**Seniors Housing, Uniting Kingscliff
Response to Request for Further Information**

This letter is prepared by Planit Consulting Pty Ltd (Planit) on behalf of the Proponent, The Uniting Church in Australia Property Trust (NSW) for Uniting (NSW.ACT) in response to the matters raised in the correspondence received from the Department of Planning, Housing and Infrastructure (the Department) dated 28 March 2025.

Table 1: Department of Planning, Housing and Infrastructure

FLOOR PLAN - GROUND LEVEL

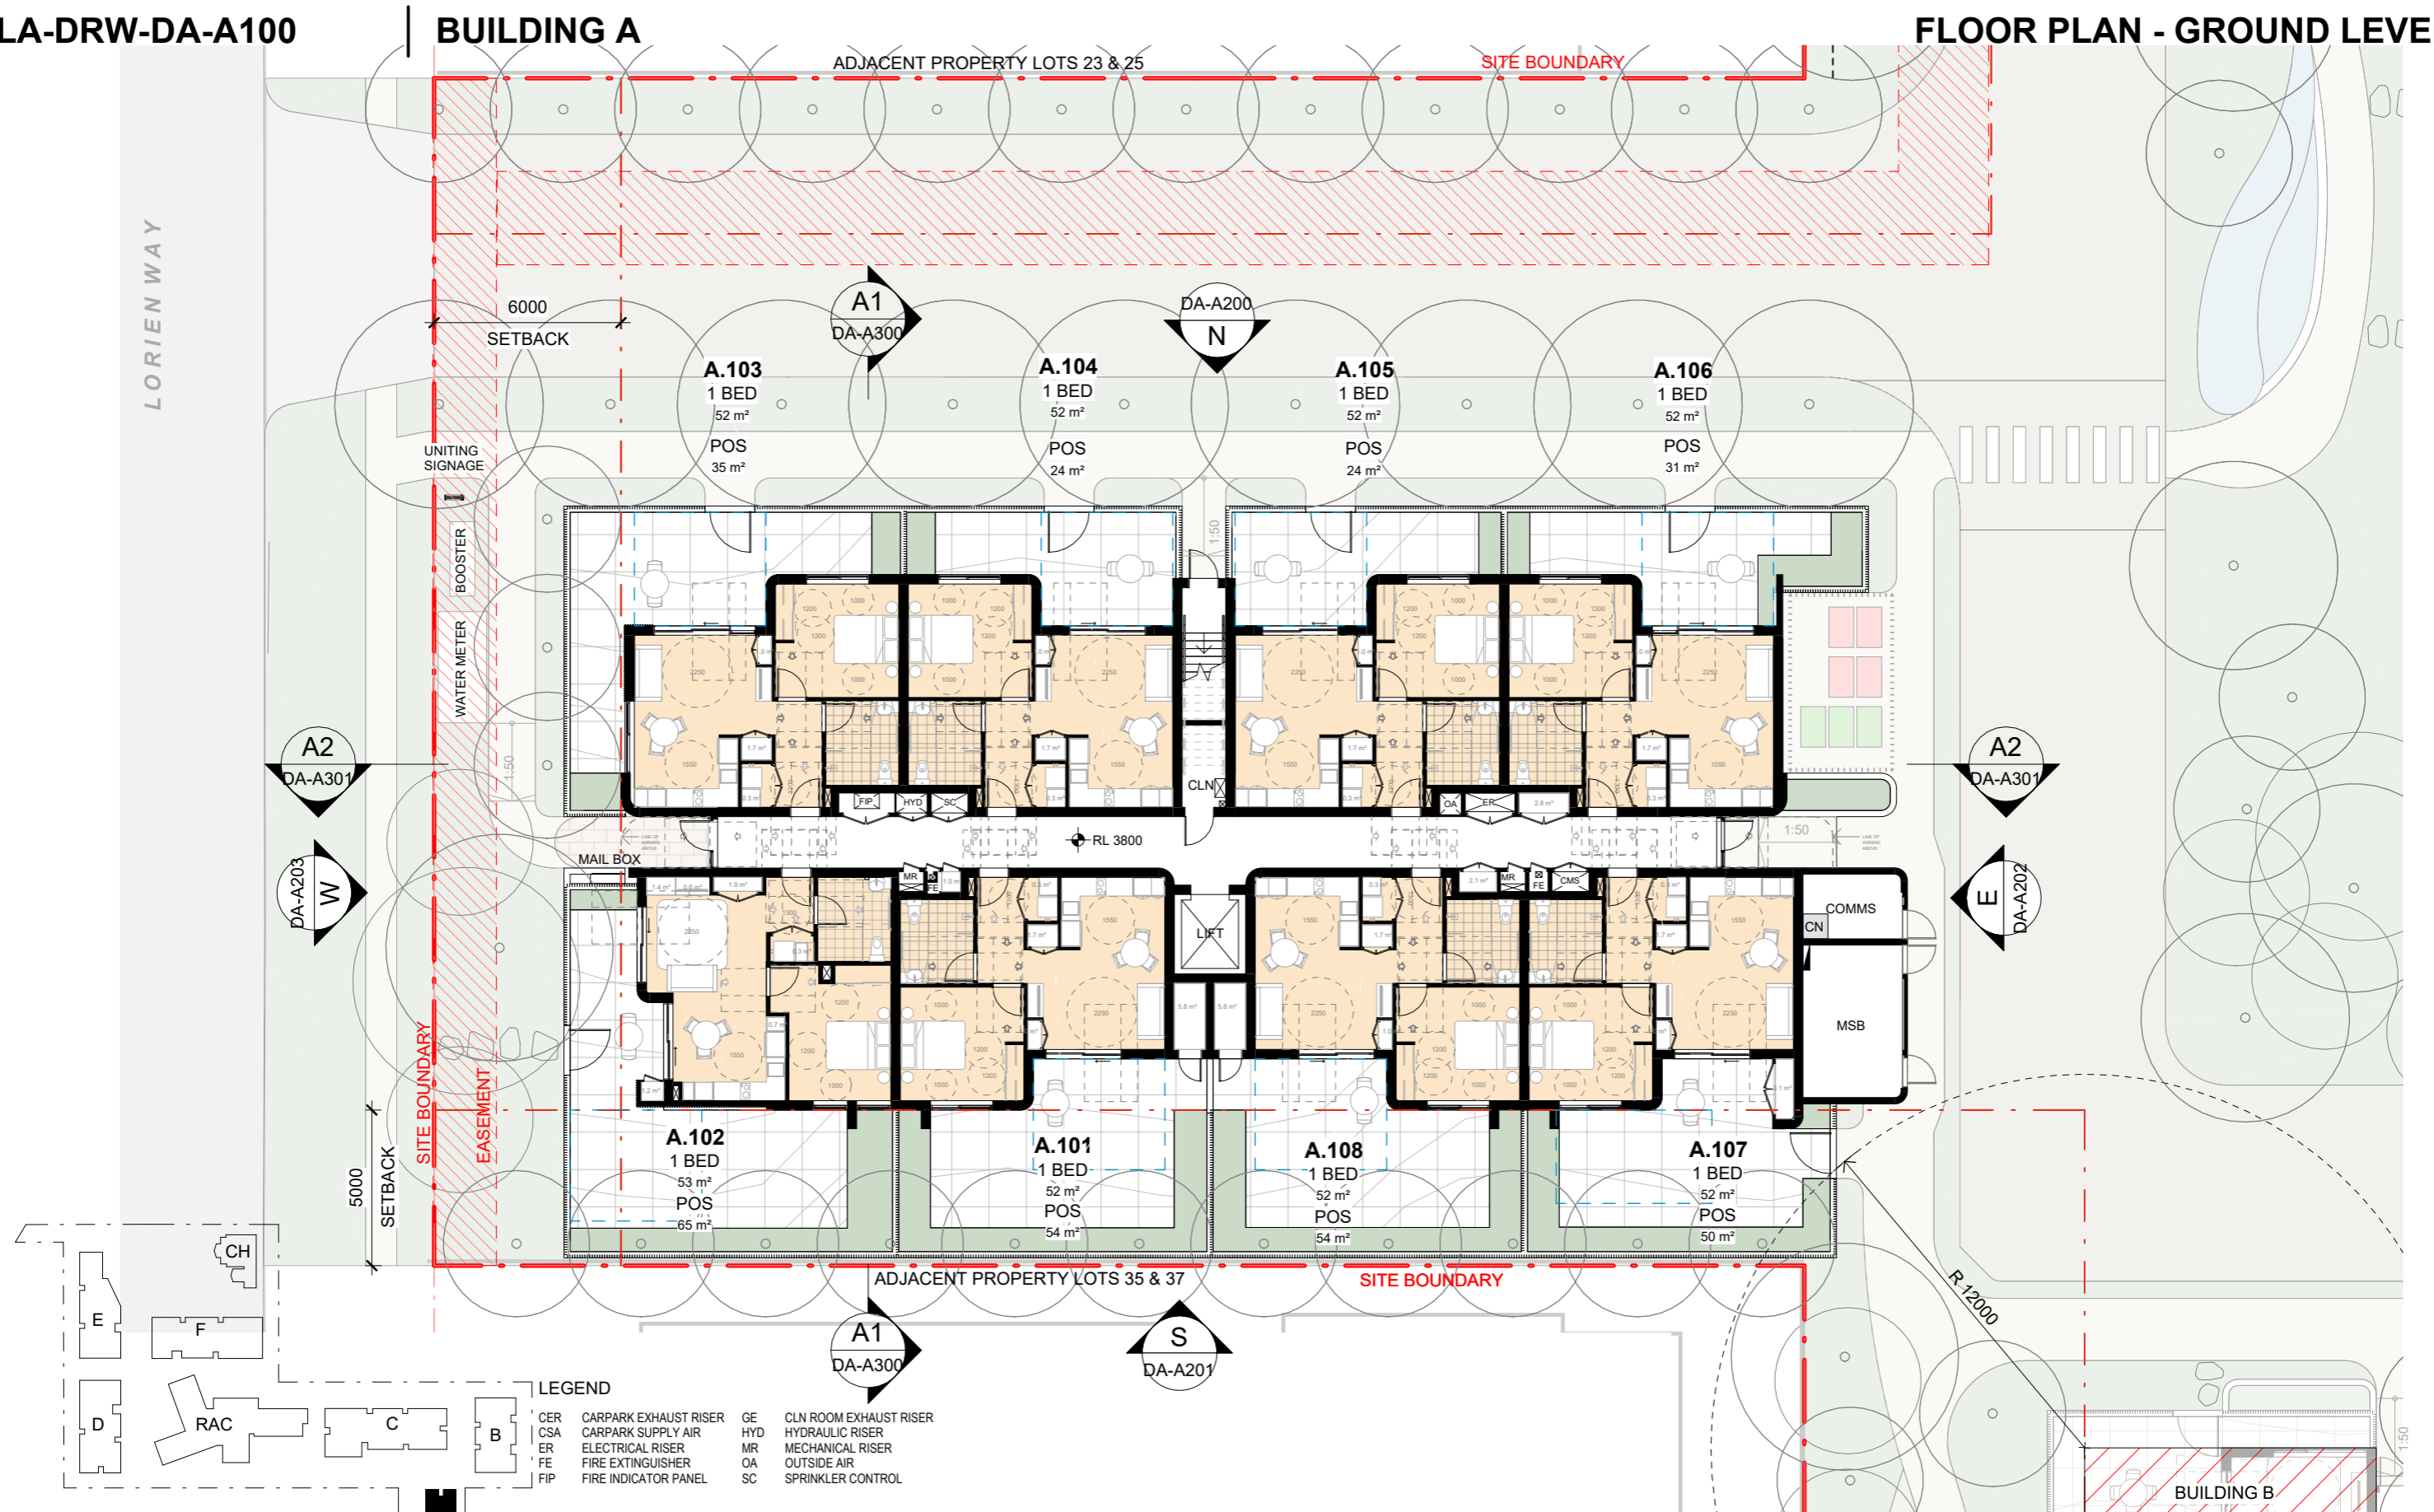
Consider relocating Building A further north, so the entire rear elevation is 6m from the shared boundary with the southern neighbour. This is requested to reduce any potential overlooking of the adjoining property. If this cannot be achieved, provide adequate planning justification for the proposed 5m setback.

Amended **Architectural Plans** prepared by Plus Architects are provided in **Attachment C** showing Building A has been relocated 1m further north, increasing the private open space provided to the ground floor units and providing a 6m setback from the shared boundary with the southern neighbour.
